Rezoning Petition Review

Date of Review: December 29, 2020

Rezoning Petition #: 20-165

Location of Property: Approximately 6.99 acres located along the south side of Mt. Holly-Huntersville Rd, the east side of Beatties Ford Rd and north of I-485.

RZ1.00

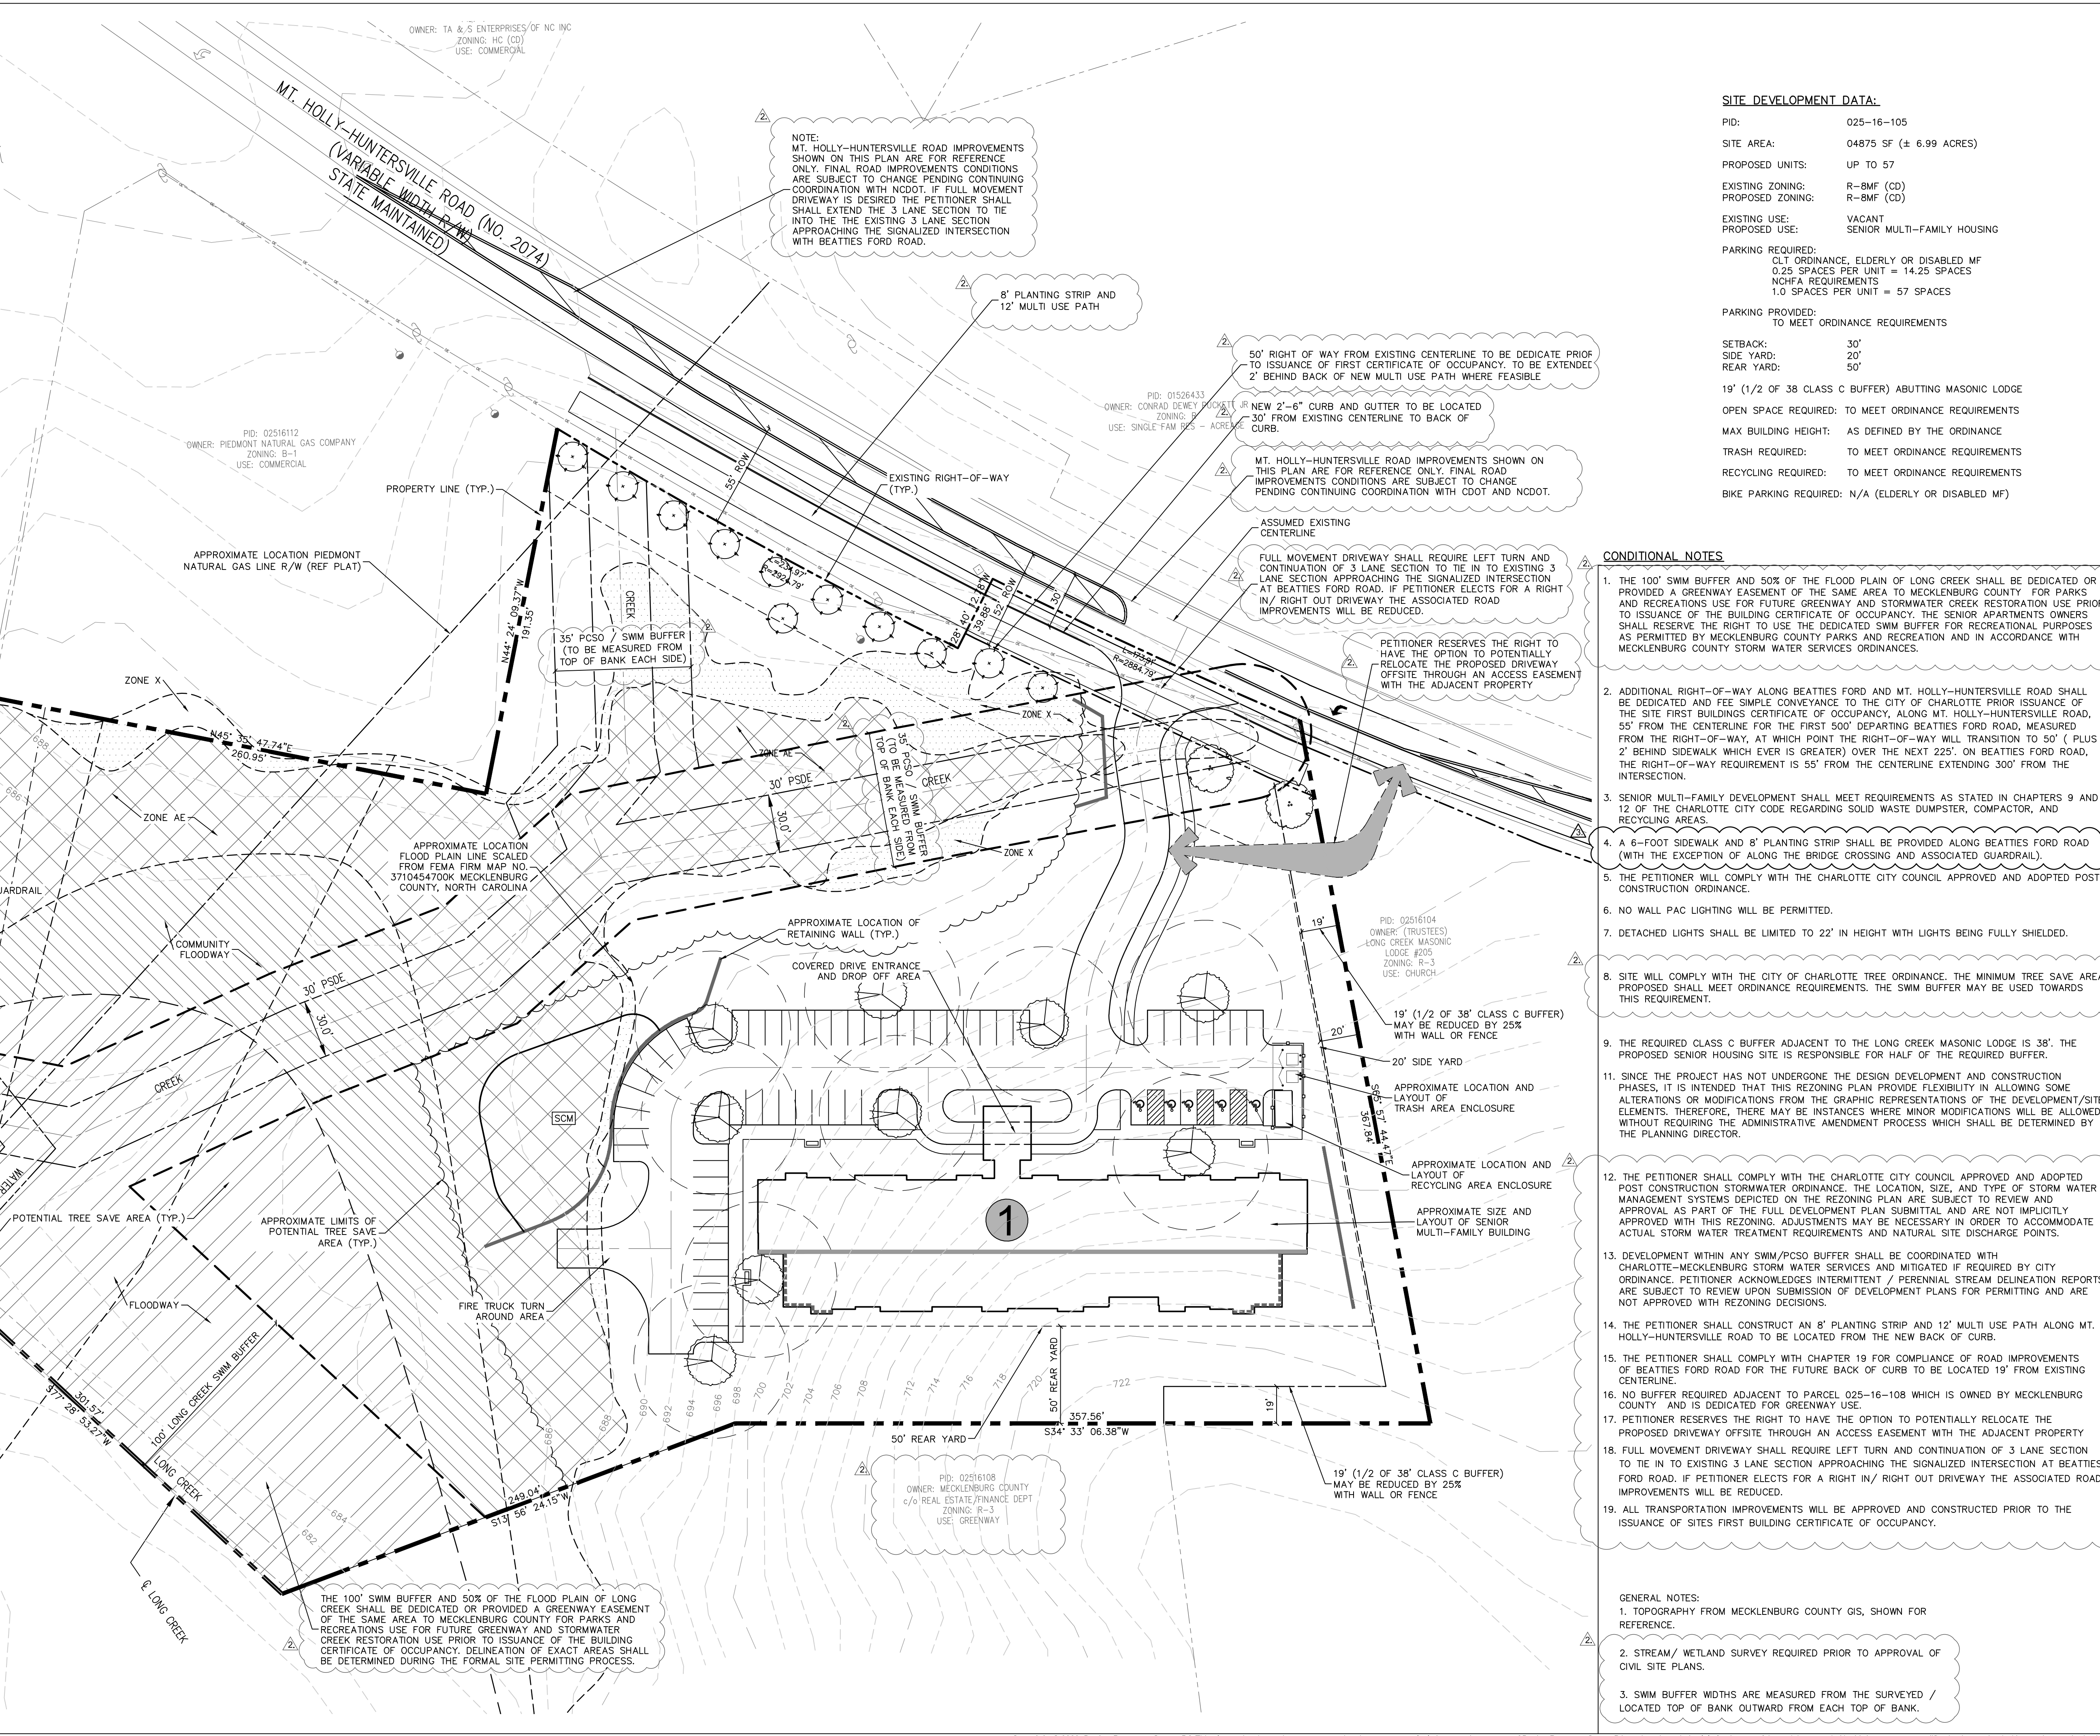
City of Charlotte GIS indicates two 35-ft PCSO/SWIM Buffers on site but only one is shown on sheet RZ-1. Please add the second potential buffer to the plan sheet.

Please revise "70' SWIM Buffer" to read "35-ft PCSO/SWIM Buffer". Note to petitioner: PCSO/SWIM buffer widths are measured from the surveyed/located top of bank and outward from each top of bank.
